Gatwick Airport Northern Runway Project

**Gatwick Airport DCO Air Quality Action Plan Review
(submitted as Appendix 5 of Draft S106 Agreement V1-
March 2024) [REP2-004]**

**Gatwick Airport DCO Construction Dust Management
Plan Review**

Deadline 4: 15 May 2024

Figure 1: GAL funded air quality monitoring locations, with monitoring undertaken by RBBC

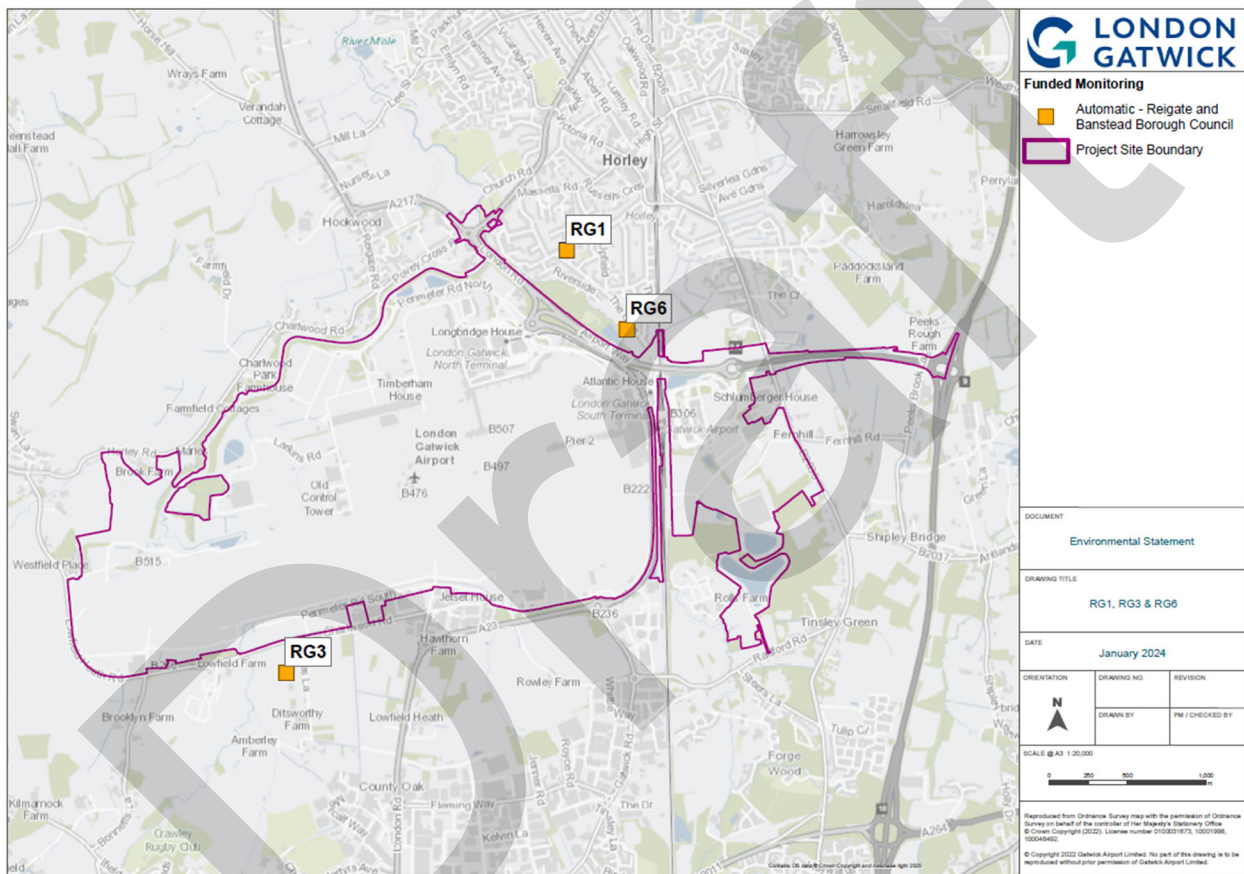
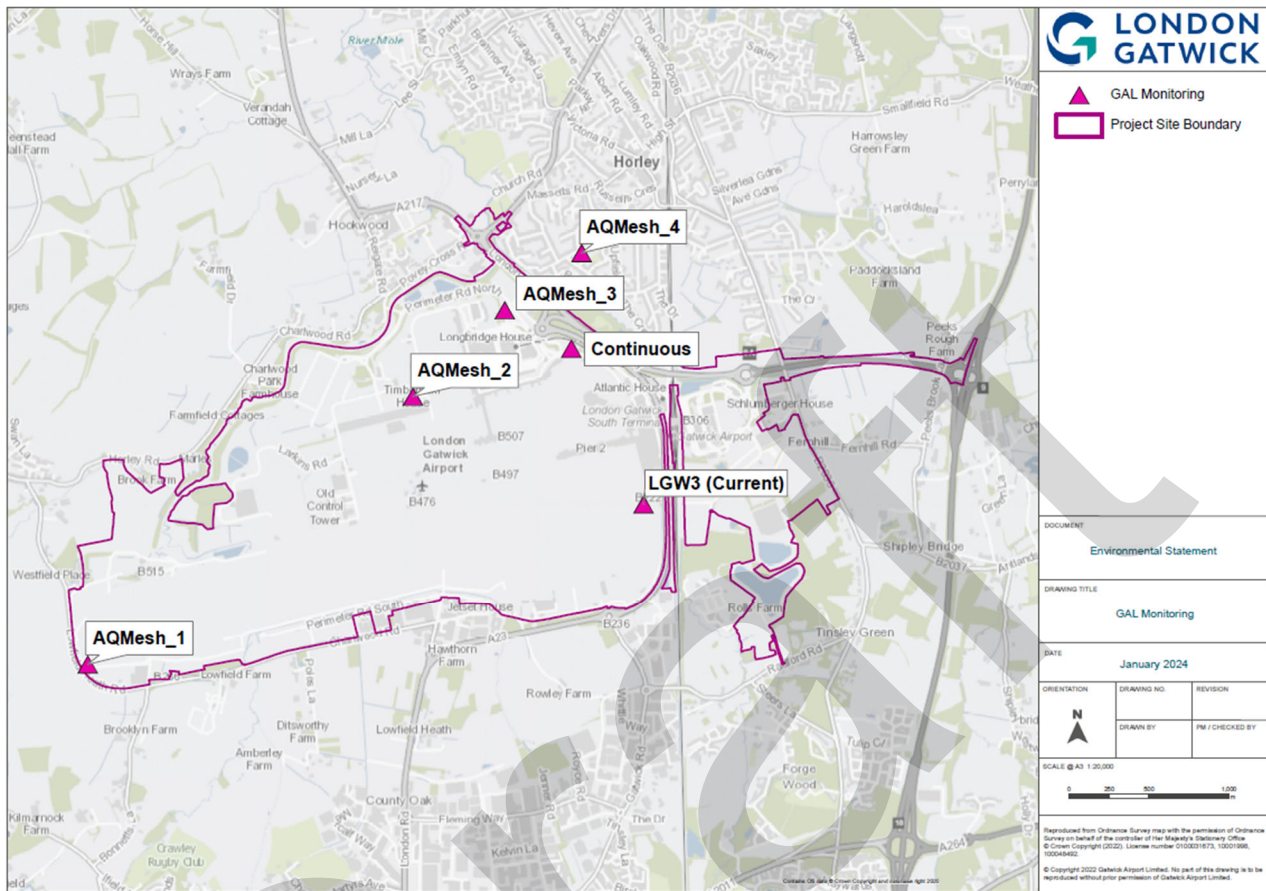
The following paragraph 4.1.4 describes that additional monitoring will be funded to increase spatial resolution, and that this will be achieved through indicative monitoring (i.e. sensors) and reference equipment. It is noted that the locations of the existing and additional monitoring seem to be focused on aircraft and airside emissions. It is not clear what monitoring will be focused on road traffic to confirm the effectiveness of the SAC. Further discussion is proposed on this point.

- Clarification on what monitoring will be focused on road traffic to confirm the effectiveness of the SAC;
 - Clarification on how the 'Monitoring Period' has been determined;
